One Earth Solar Farm

Applicant Response to ExA's First Written Questions

Document Ref: EN010159/APP/9.19

August 2025

Figure 11.1: Site Location and Study Area

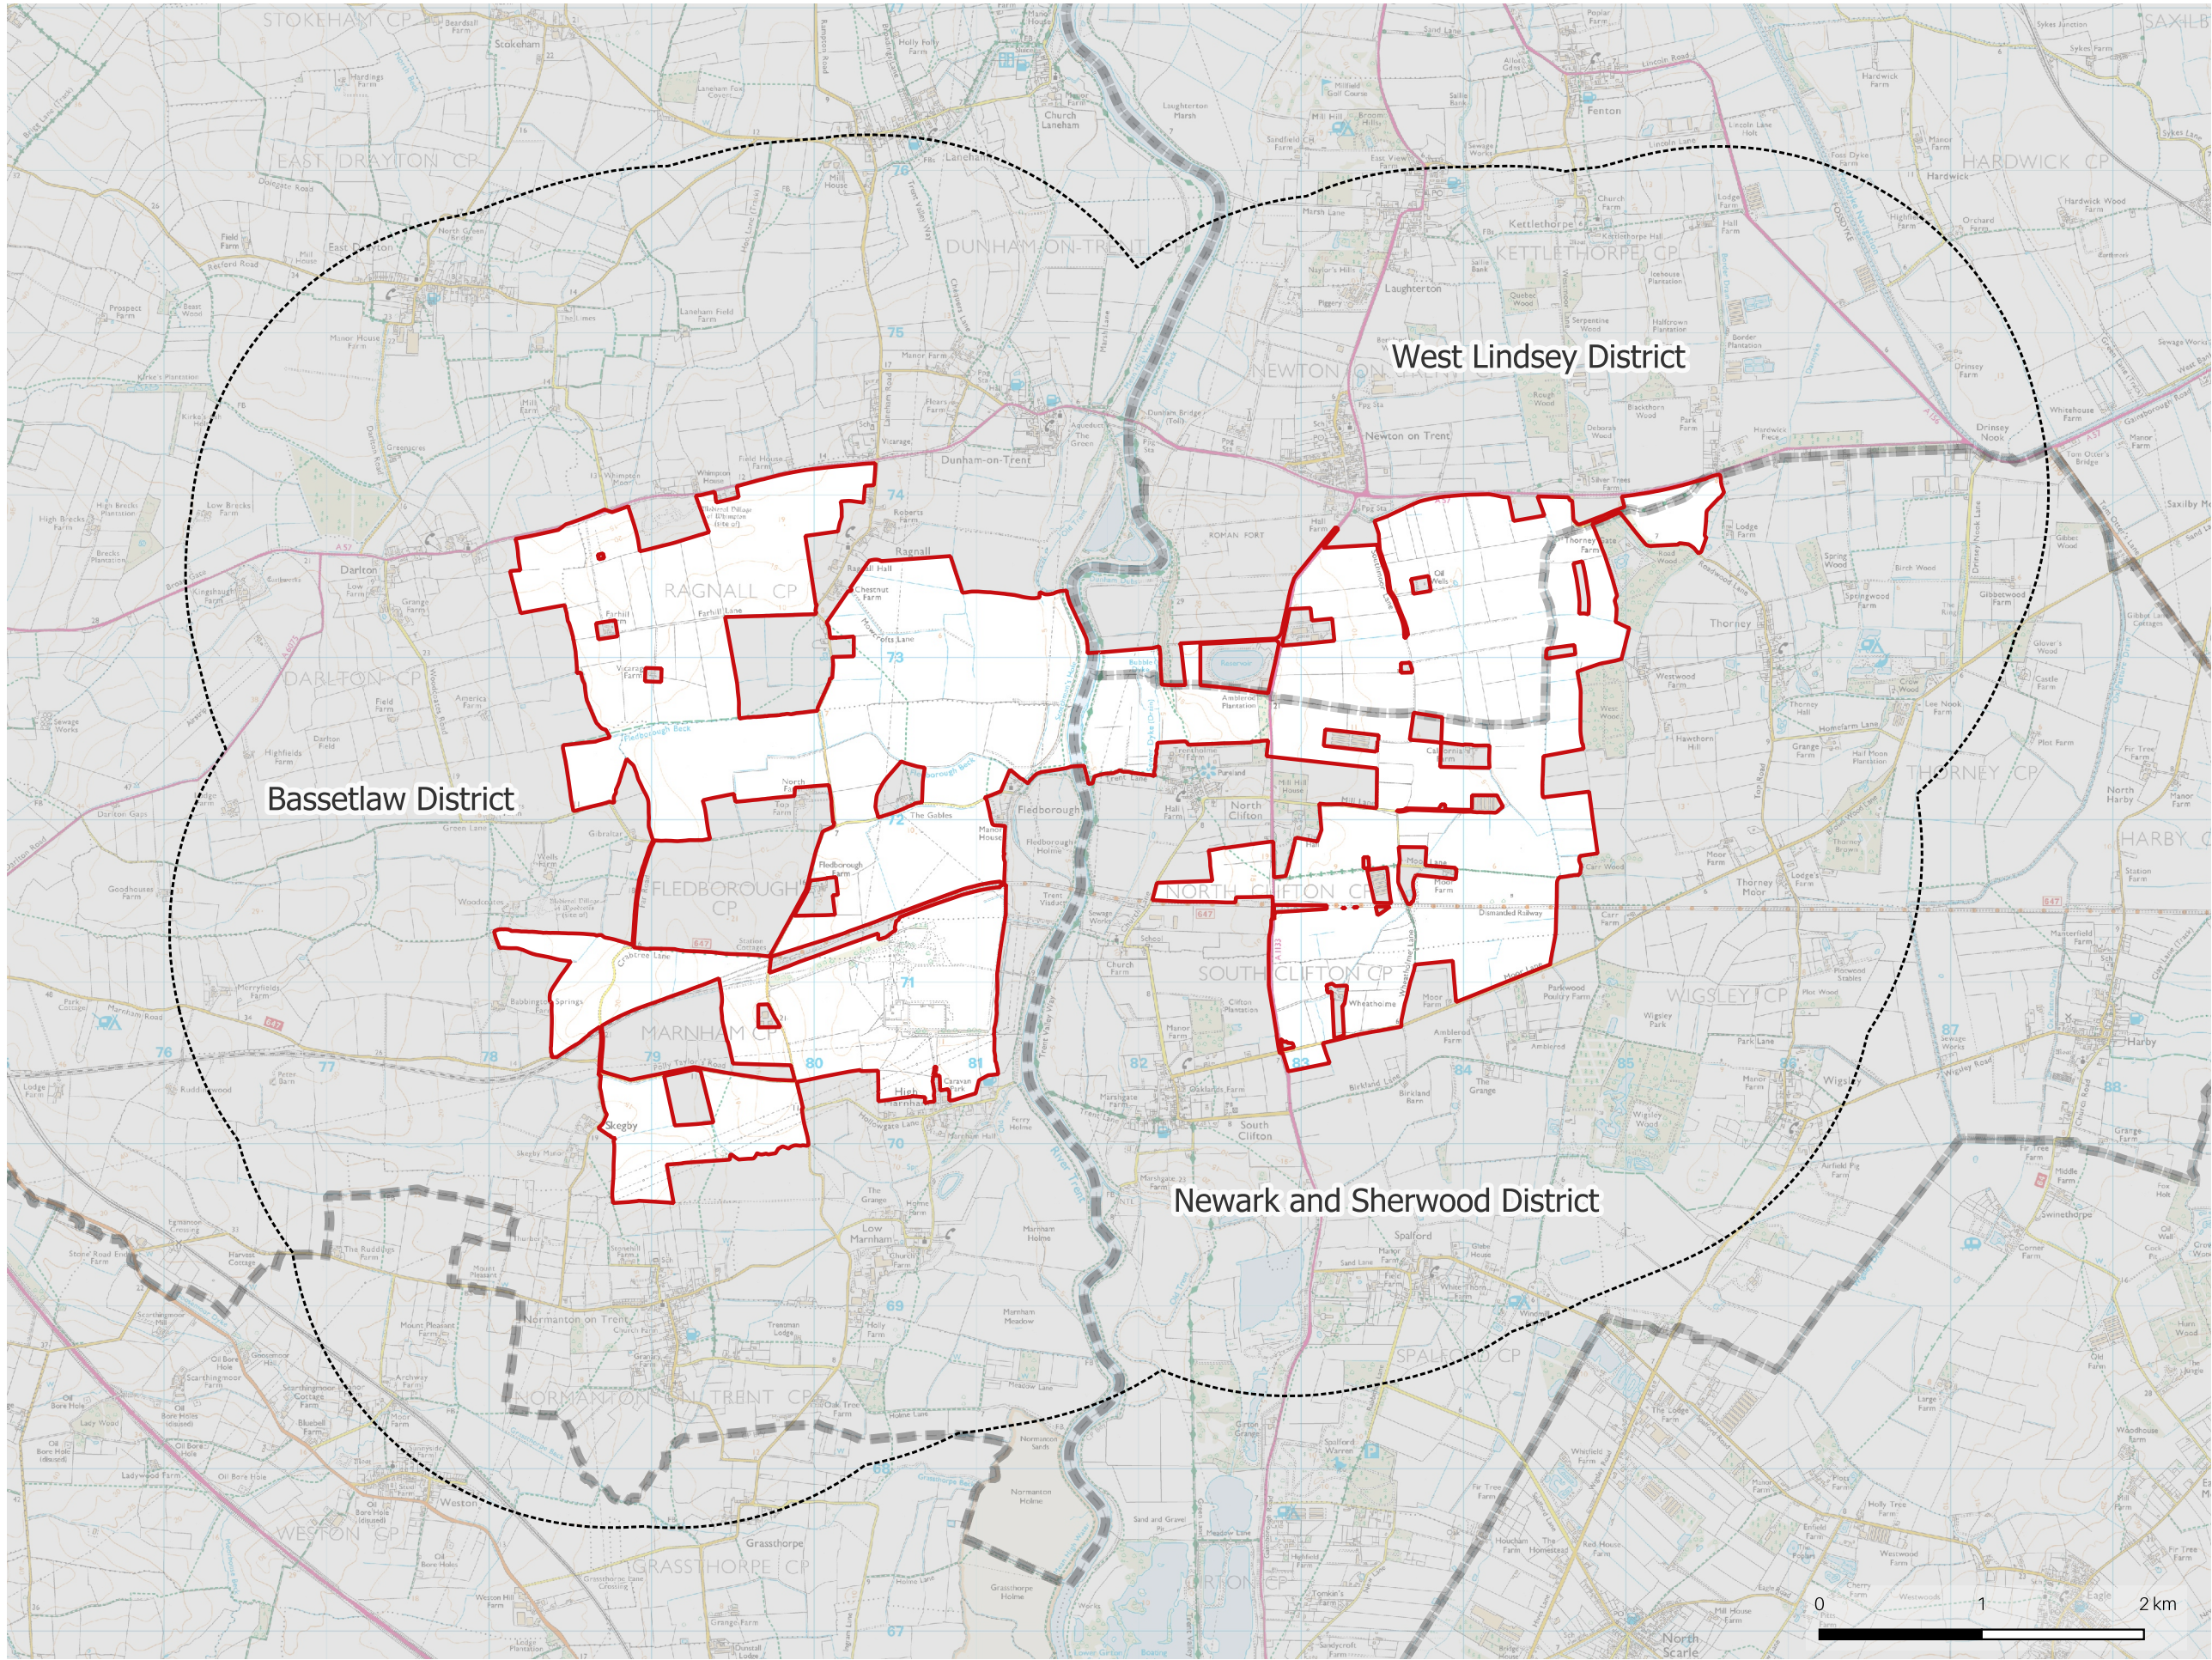
Q1.0.10	The Applicant	Locations of Photographs In ES Vol 3 Figures 11.1-11.14 – Part 16 The Viewpoint locations appear to be slightly different locations from the versions provided elsewhere, please explain the discrepancy.	<p>The ES Vol 3 Figures relating to Chapter 11 were resubmitted by the Applicant in response to the Rule 17 letter to provide further clarity in the file name on what was included within each document – see [AS-019 to AS-043].</p> <p>The Applicant confirms that the viewpoint locations shown on the thumbnails for each photomontage [AS-037 – AS-043] are correct and consistent with the representative viewpoint location plan [AS-029] and the baseline photography [AS-031 – AS-036].</p> <p>The thumbnails for each photomontage do however show a superseded version of the Order Limits which has been updated at Deadline 2.</p>
